DECISION DELEGATED TO HEAD OF PLANNING

Application No: H16-1056-24 **Applicant:** Dr I Razaq

Proposal: Details of windows, staircase & fencing (Conditions 3, 4 & 5 of H16-0239-23)

Location: 15 High Street Spalding

FENCES HEIGHT

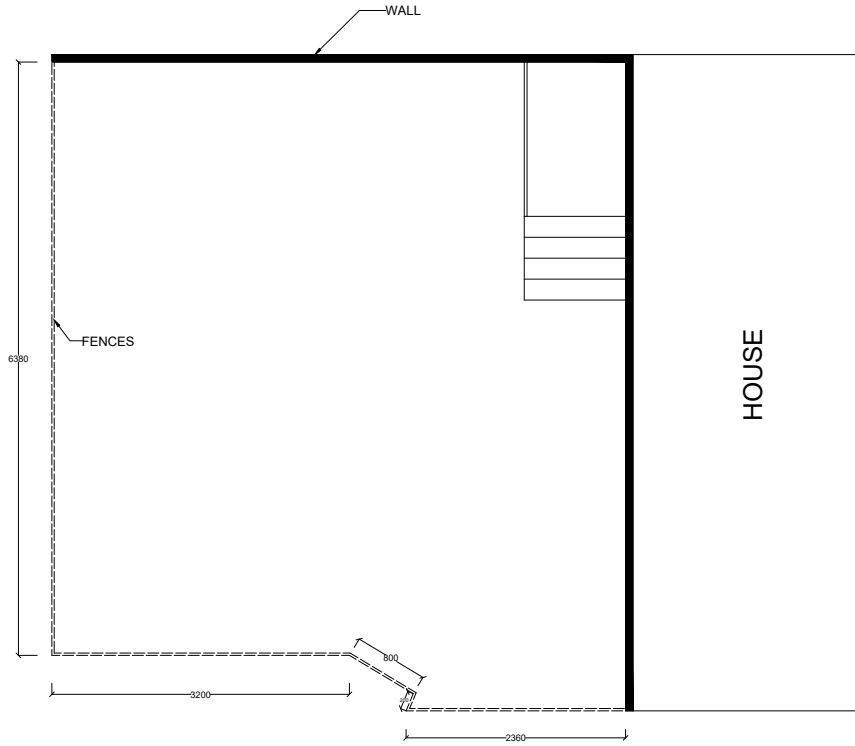
The applicant has submitted details of the proposed rear boundary treatment, proposing a standard 1.8m close-boarded fence. Such a fence is typically not considered to be acceptable in the context of a listed building, appearing impermeable and thoroughly modern in appearance. To allow such a quality of fencing, which is out of keeping with the character of the listed property, and would appear to 'hem-in' the rear of the property from a relatively open rear, would therefore harm the historic environment in a fashion that is as yet unjustified. Thus condition therefore cannot be discharged using the submitted details.
